# Letter of Intent for Monument Glamping Special Use Modification, Fall 2023

## Monument Glamping El Paso County, Colorado

PCD File No. AL2321  
Prepared: August 11, 2022  
Addended: September 30, 2023

MONUMENT GLAMPING SITE PLAN
16315 RICKENBACKER AVE.
MONUMENT, CO 80132

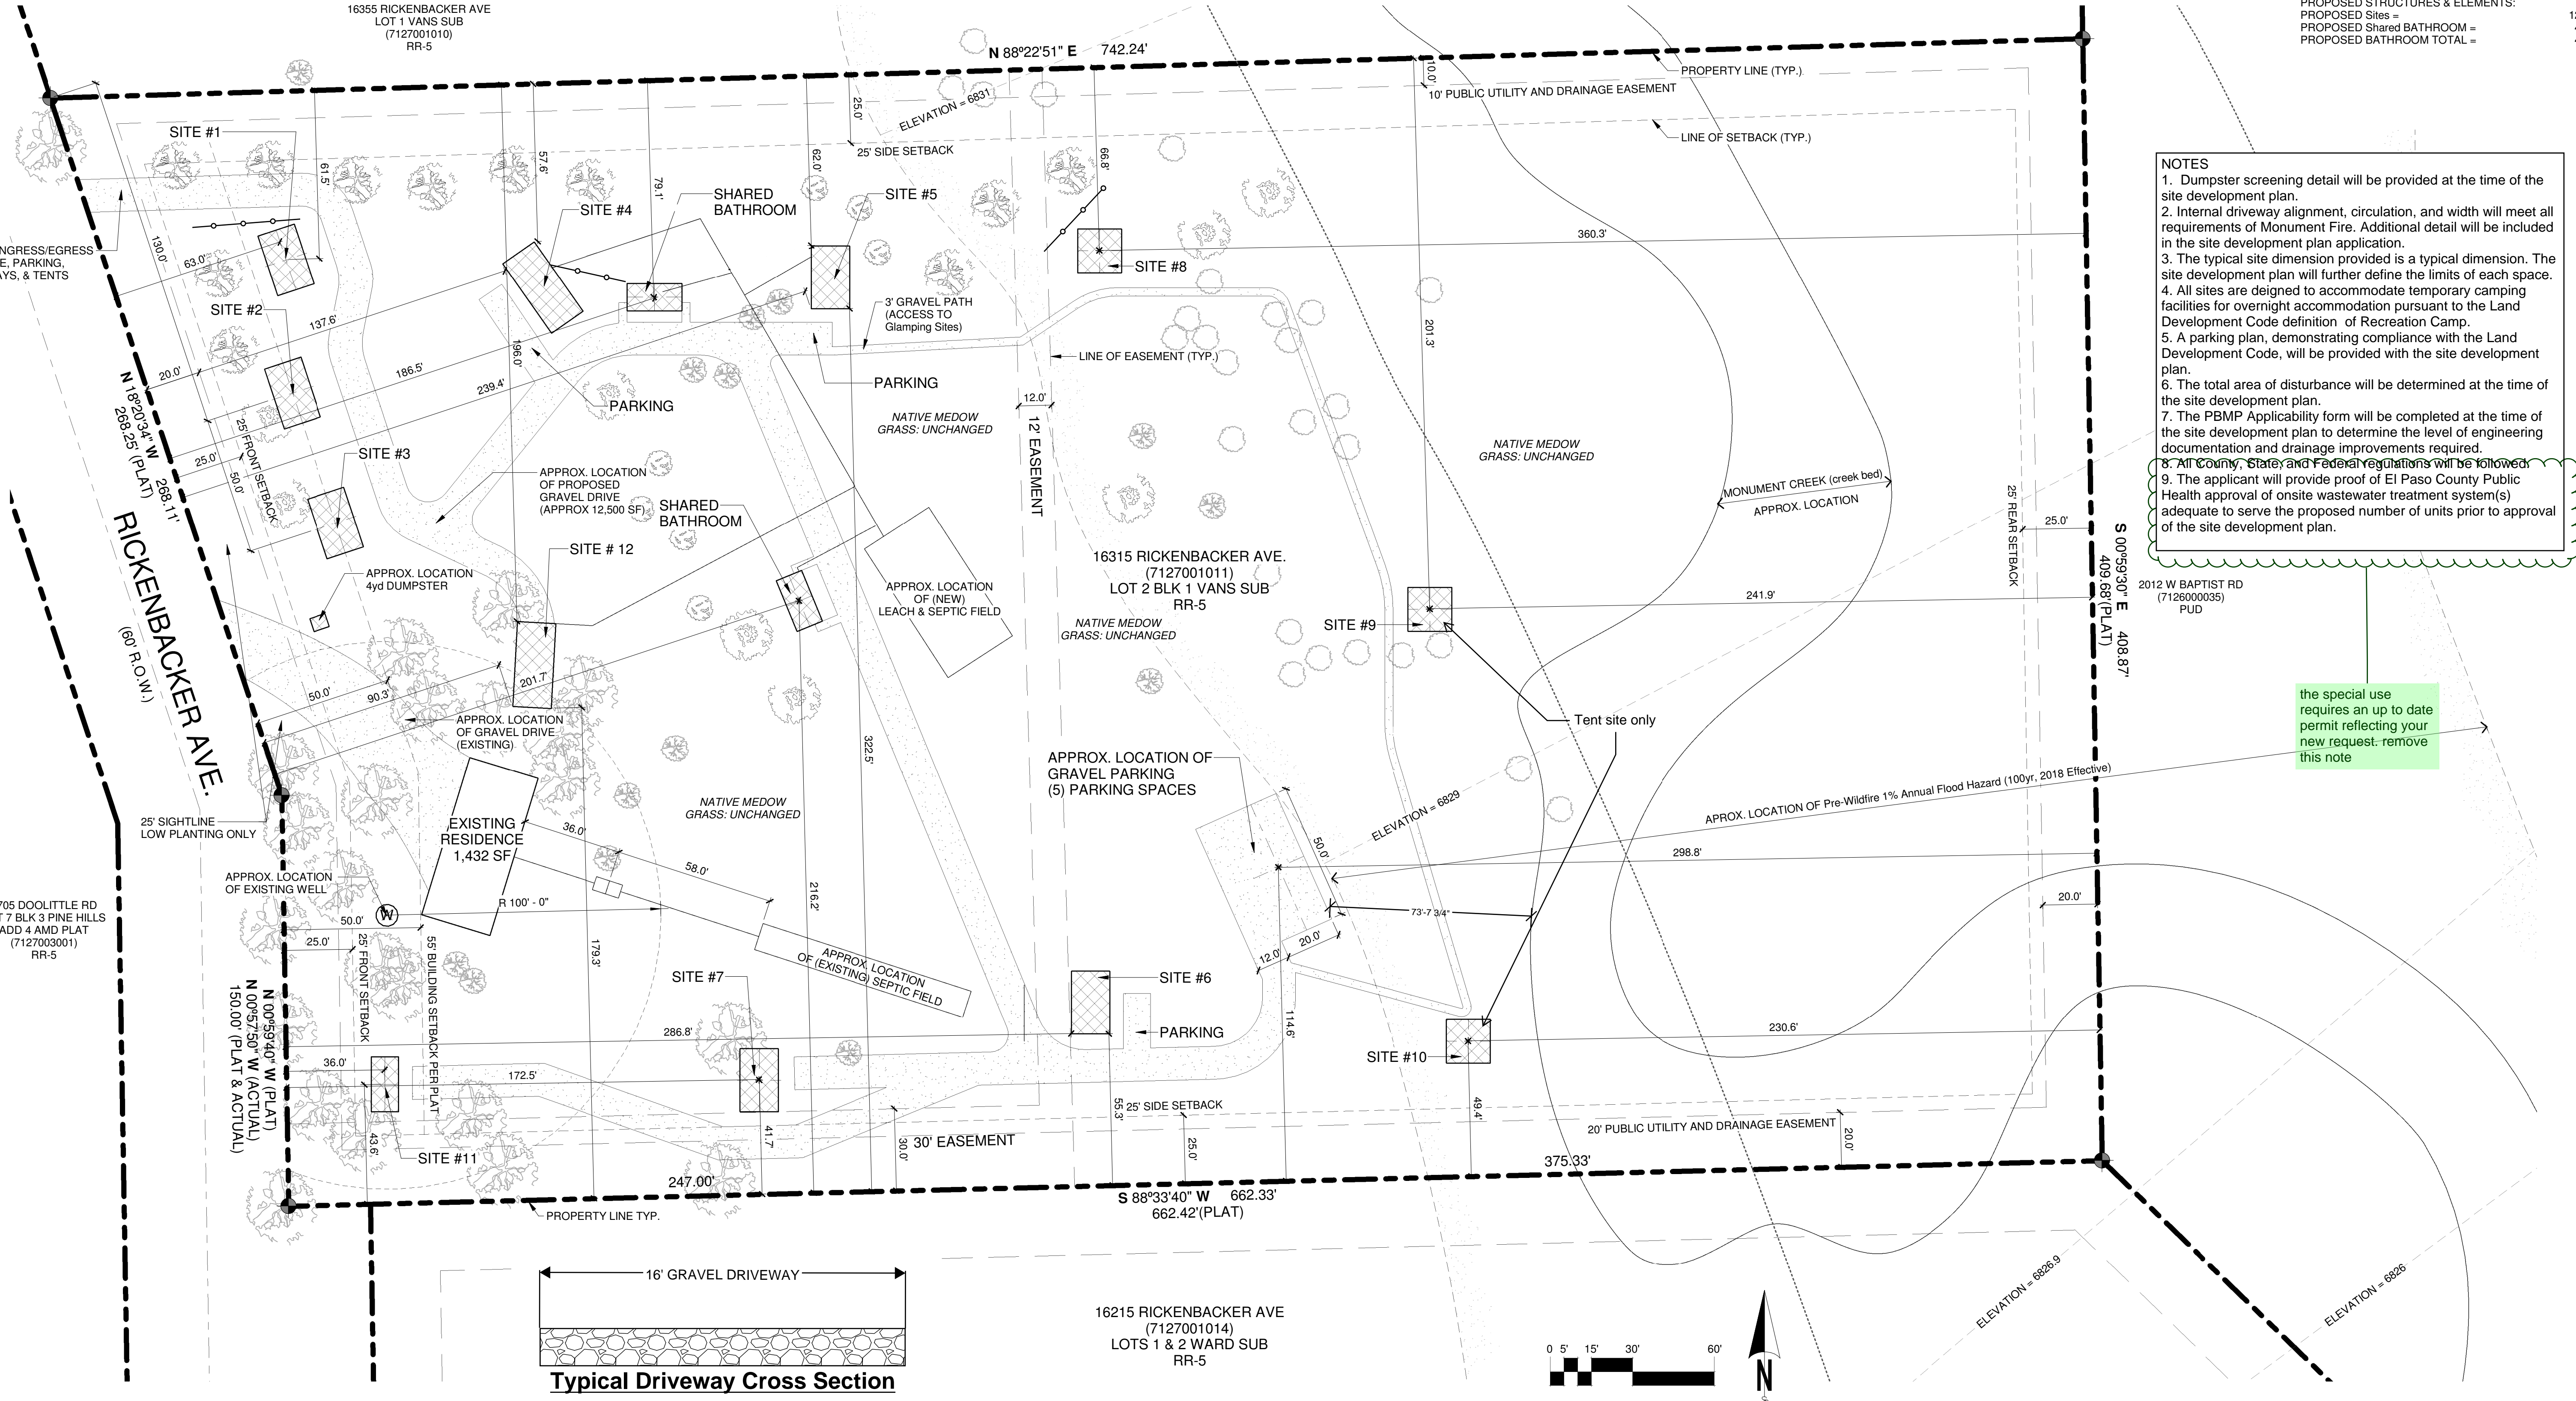
**8/30/23 from Floodplain Director:** ““Non-tent structures" like cabins or tiny homes located in the SFHA need to be elevated to 1 foot above BFE and constructed to resist floatation and or collapse under the pressure of flood waters, or be on wheels road-ready, and be approved for highway travel. The three sites in the floodplain need to remain tent sites.”

**9/19/23 from Engineering:** “Provide a statement confirming the proposed request to allow different sites will not adversely impact adjacent properties or existing stormwater runoff patterns and clarify no additional land disturbance is being proposed.”

**9/26/23 from EPC Code Enforcement:** “Unpermitted modified shipping container located at the far southwest corner of the property is not included in the submittal and it is in violation of the required 25ft. setback.”

**Addendum:** All structures within the floodplain will remain tents.

**Addendum:** This request to allow different sites will not adversely impact adjacent properties or existing stormwater runoff patterns. The sites will remain in the same places as noted in the Site Development Plan, so no additional land disturbance is being proposed.

**Addendum:** The shipping container is a temporary unit and not intended to be a part of this special use application. This unit is planned to be a part of a separate application for a second glamping property. We ask Code Enforcement to allow the container to remain in its current location until a new suitable site for it is approved in the second application to prevent having to move it twice.

PROPOSED STRUCTURES

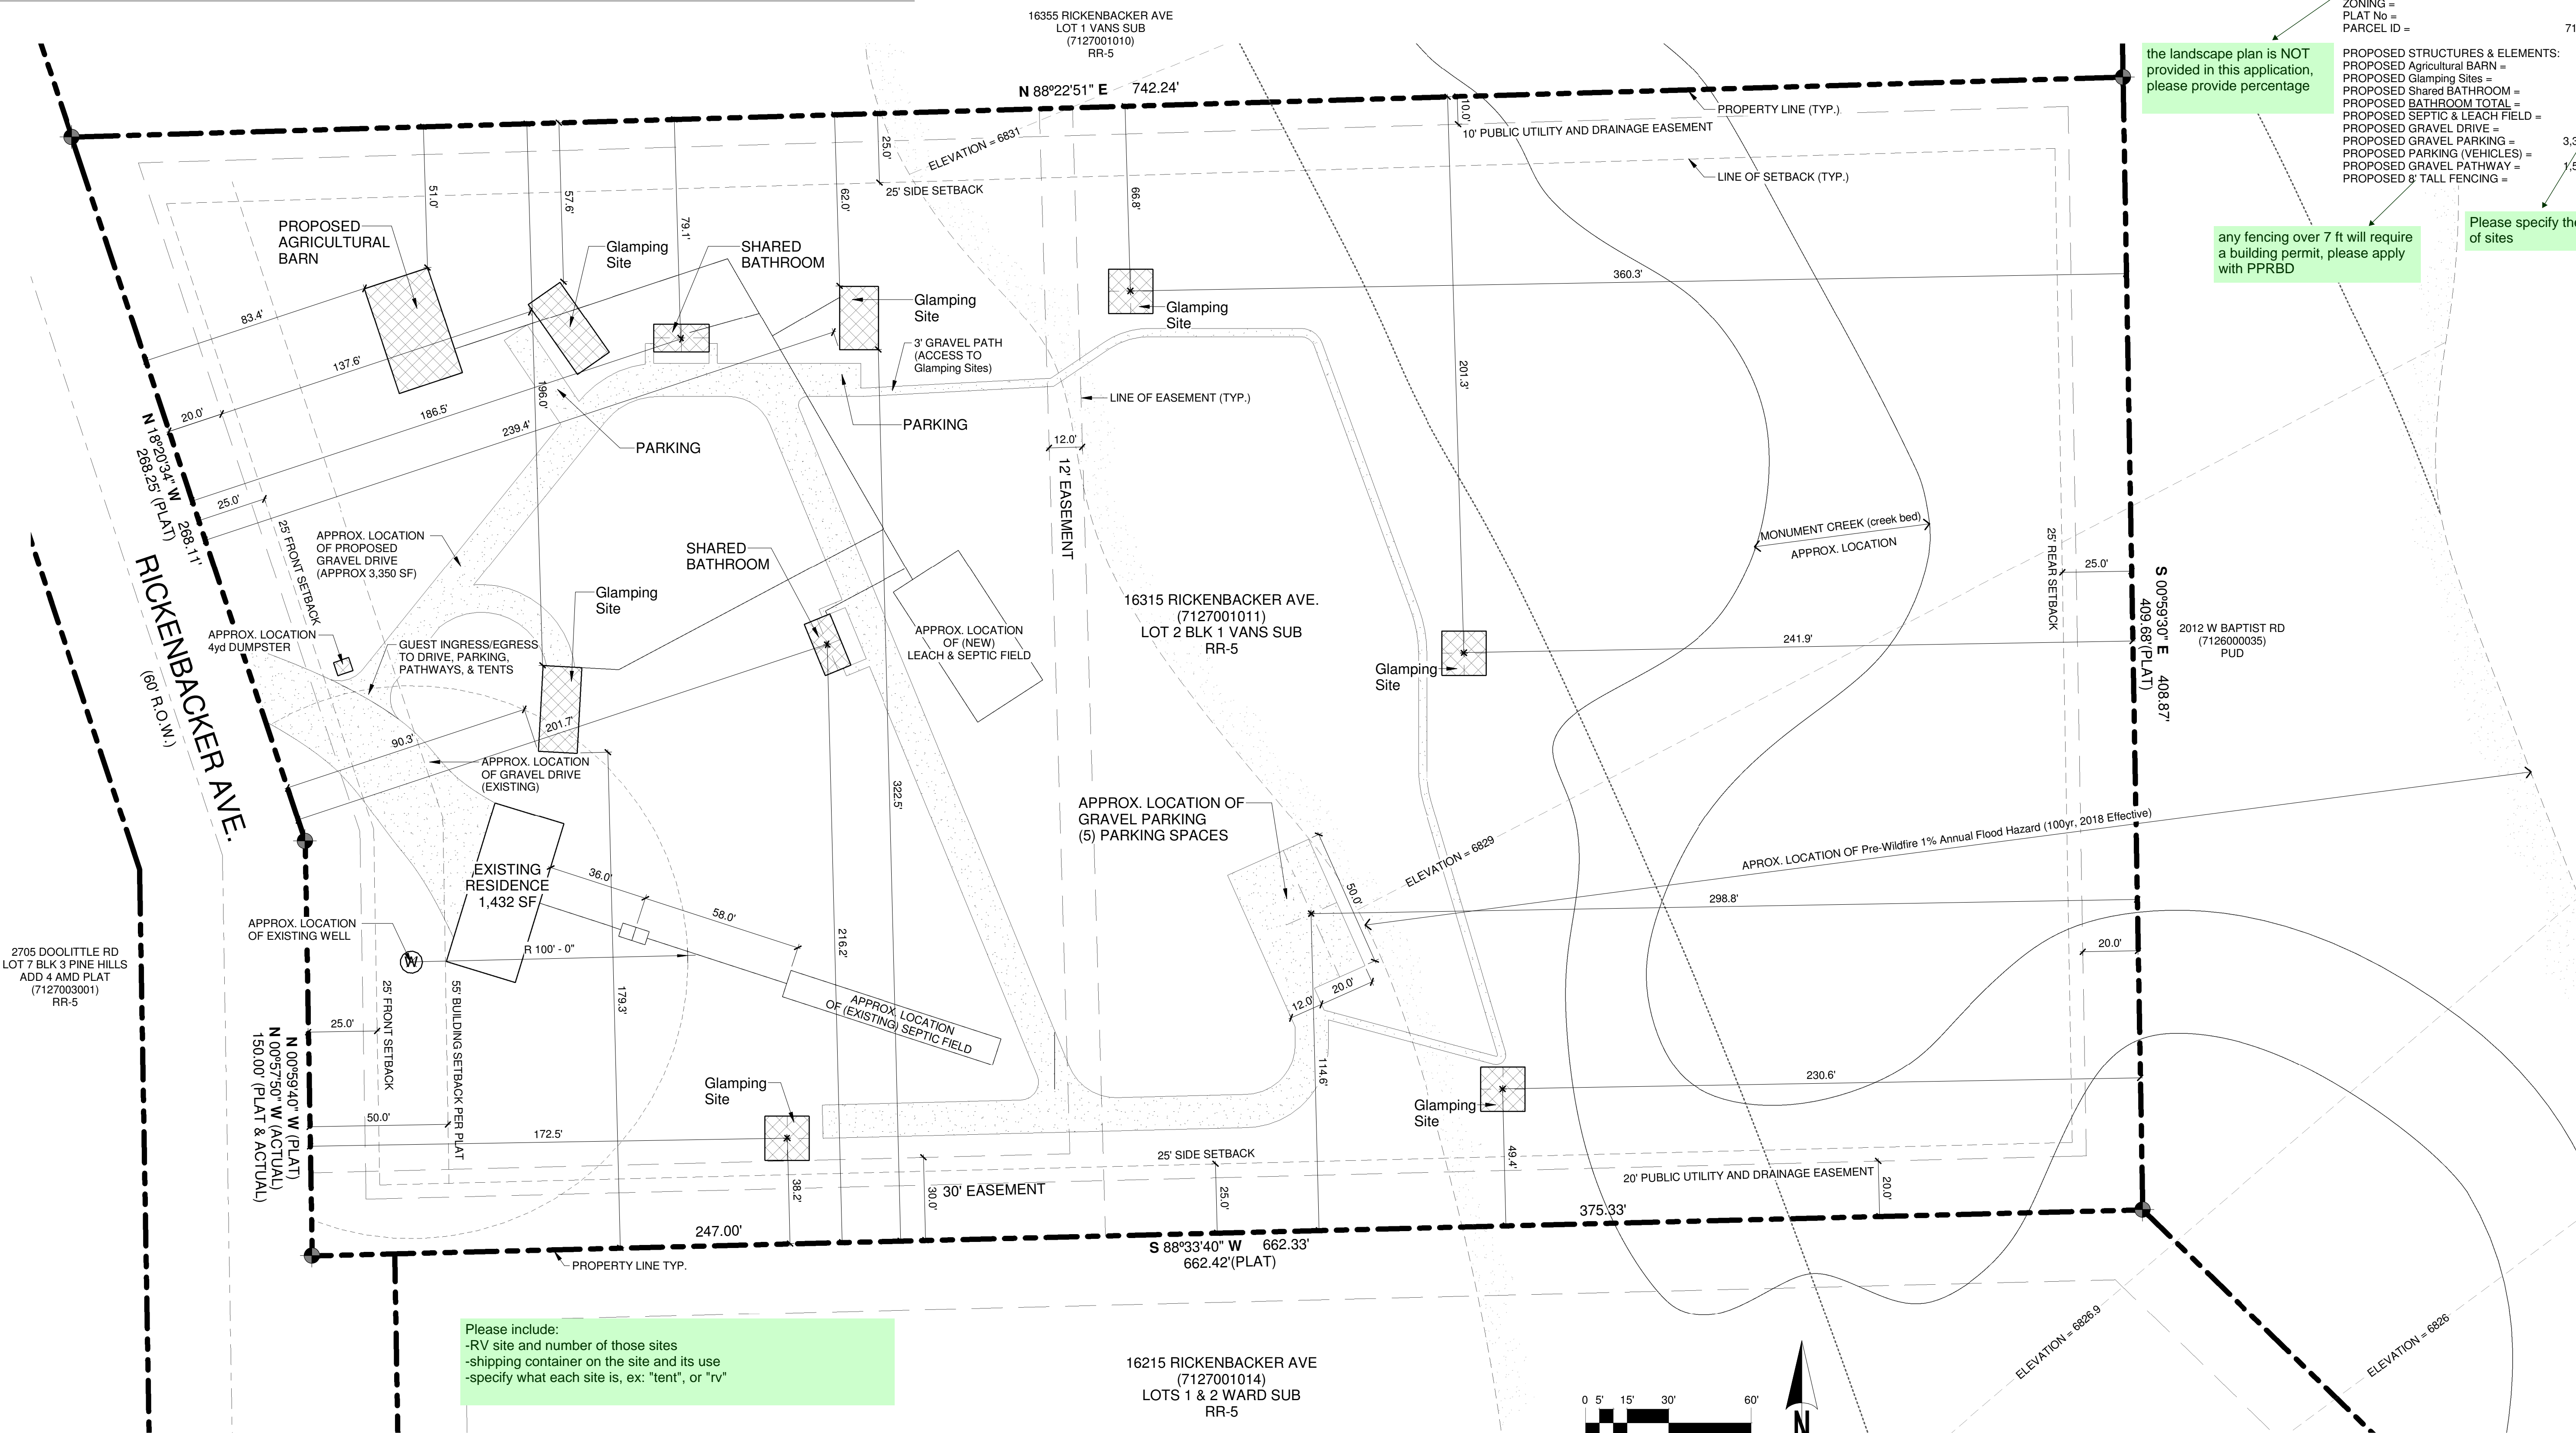
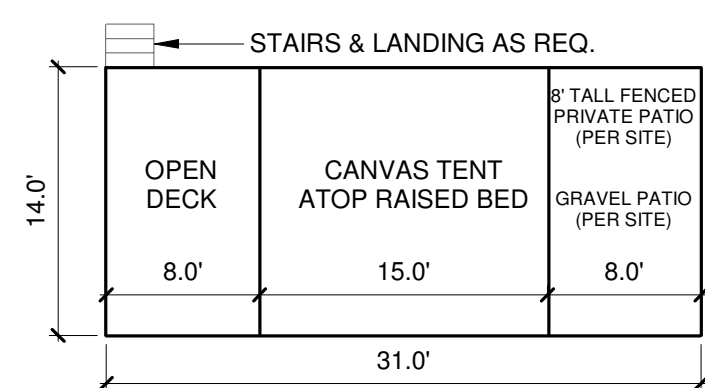
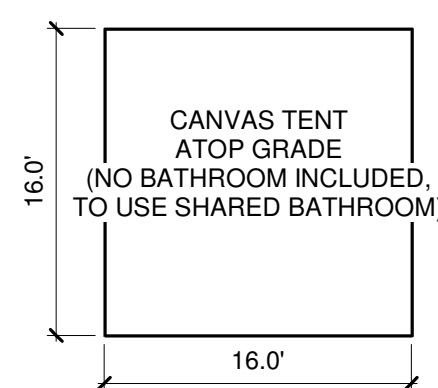
PLEASE REVISE:  
you are changing the type of site and it must be specified in the letter of intent and site plan
